Your ref: 21.1134
Our ref: D3.21.1134
Date: 3rd December 2021

App no: 21.1134

Address: Land east of Chipping Lane, Longridge

Proposal: Development of Phases 2 and 3 for the erection of 198 dwellings, including affordable housing and housing for older people, with associated landscaping, SUDS, LEAP, and areas of open space.

Drawing file: planx_downloads / 21_1134_Amend_det_garage_stone_010422.pdf

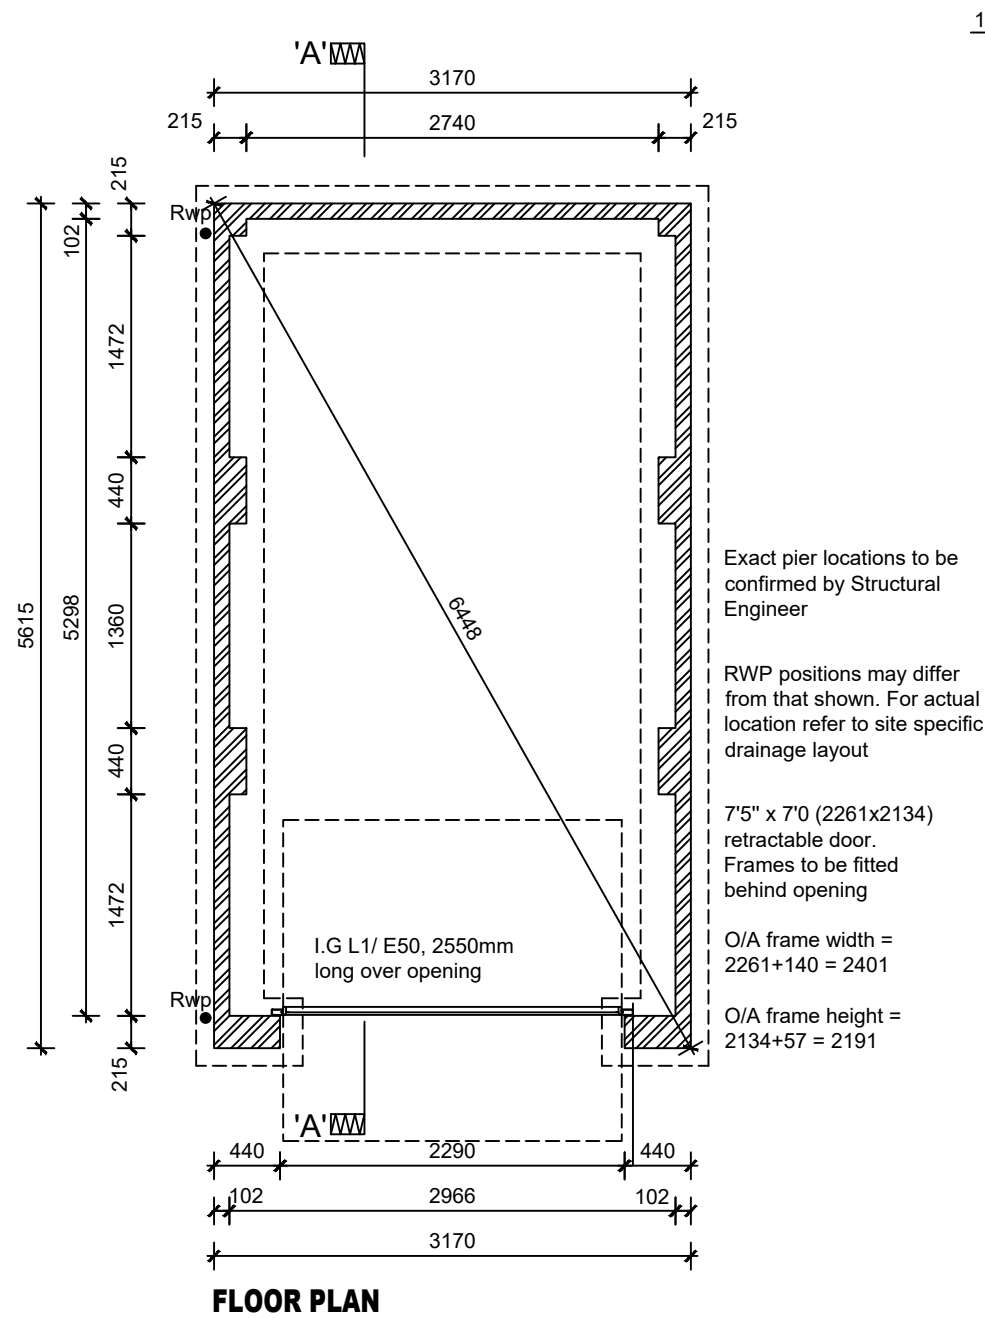
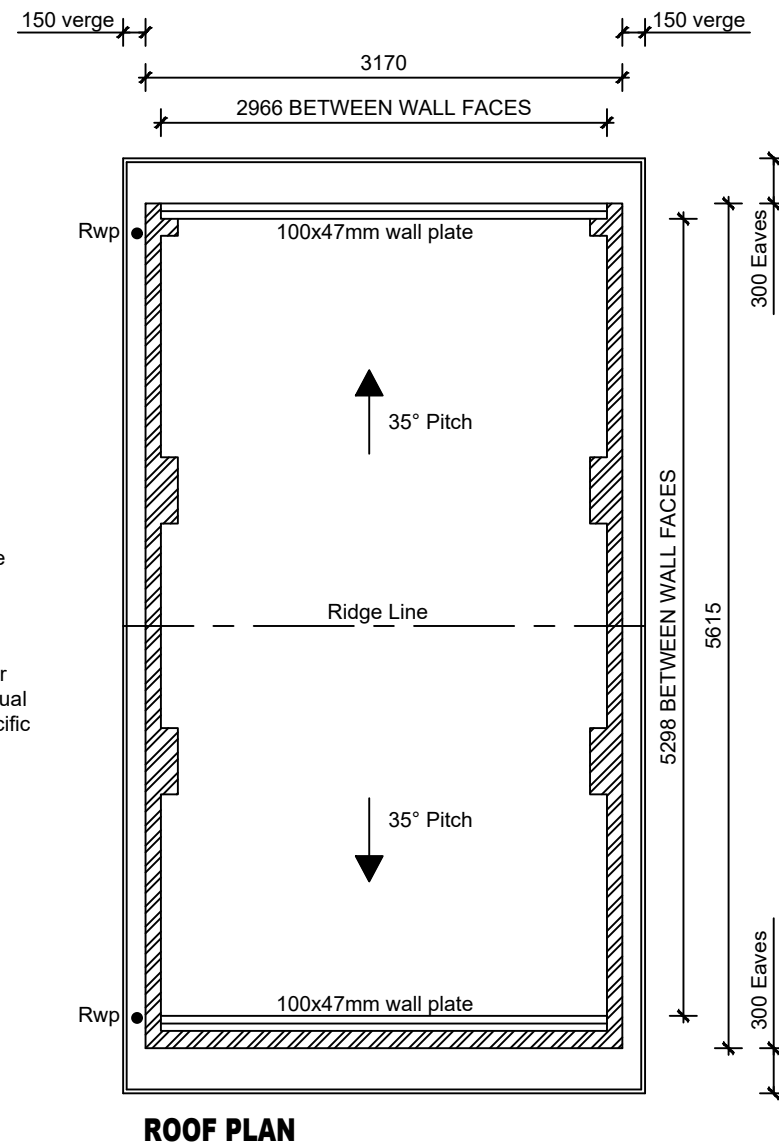
The proposed garages are below the recommended size of 3m x 6m to count as a parking space, the Denby and Winfield are 5m x 2.6m and 4.9m x 2.4m respectively. They can be counted as secure, cycle parking. I can't see a drawing for the detached garages so I cannot comment upon their sizes.
